Application No: LU/97/22/HH
Site Address: 3 Paterson Wilson Road Littlehampton BN17 6EJ
Description of works: Installation of cement board cladding.

Thank you for your internet representation made on 31st May 2022 which has been recorded as an objection with the comments as follows:

DRAWING TITLE
Proposed Elevations

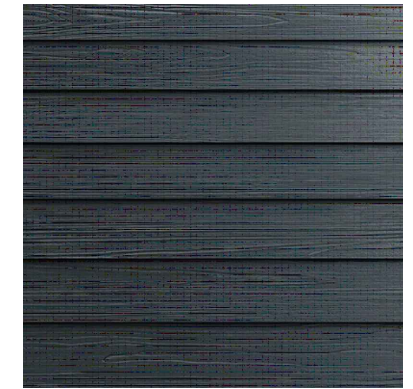
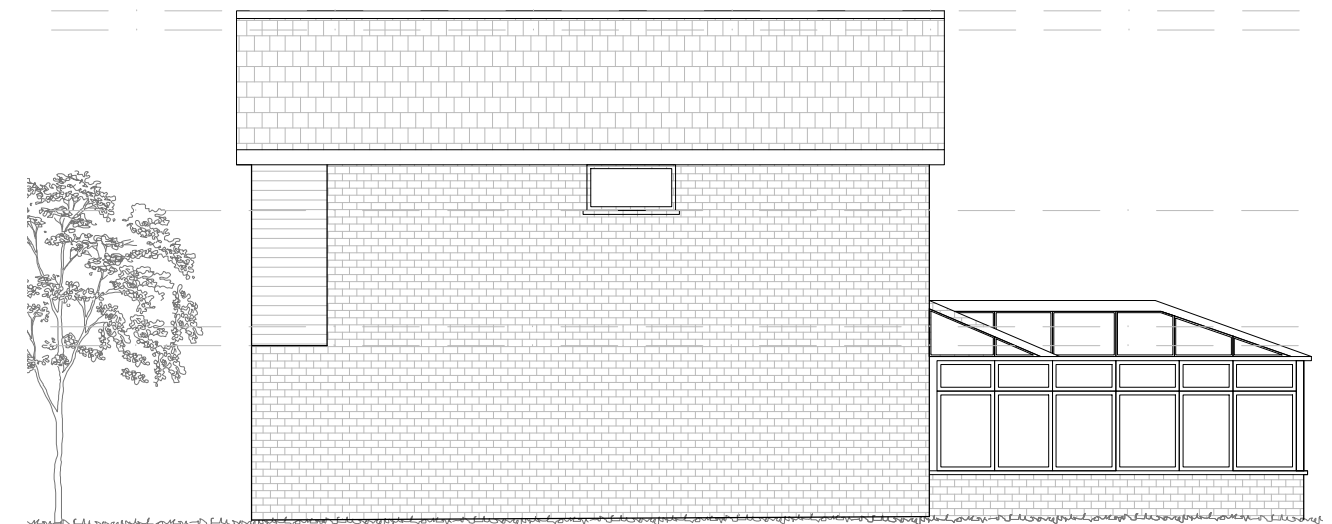
The Town Council's Planning and Transportation Committee considered this application at their meeting held on Monday 23 May 2022 and object to the application - the proposed cladding would be out of keeping with the character and appearance of neighbouring houses.
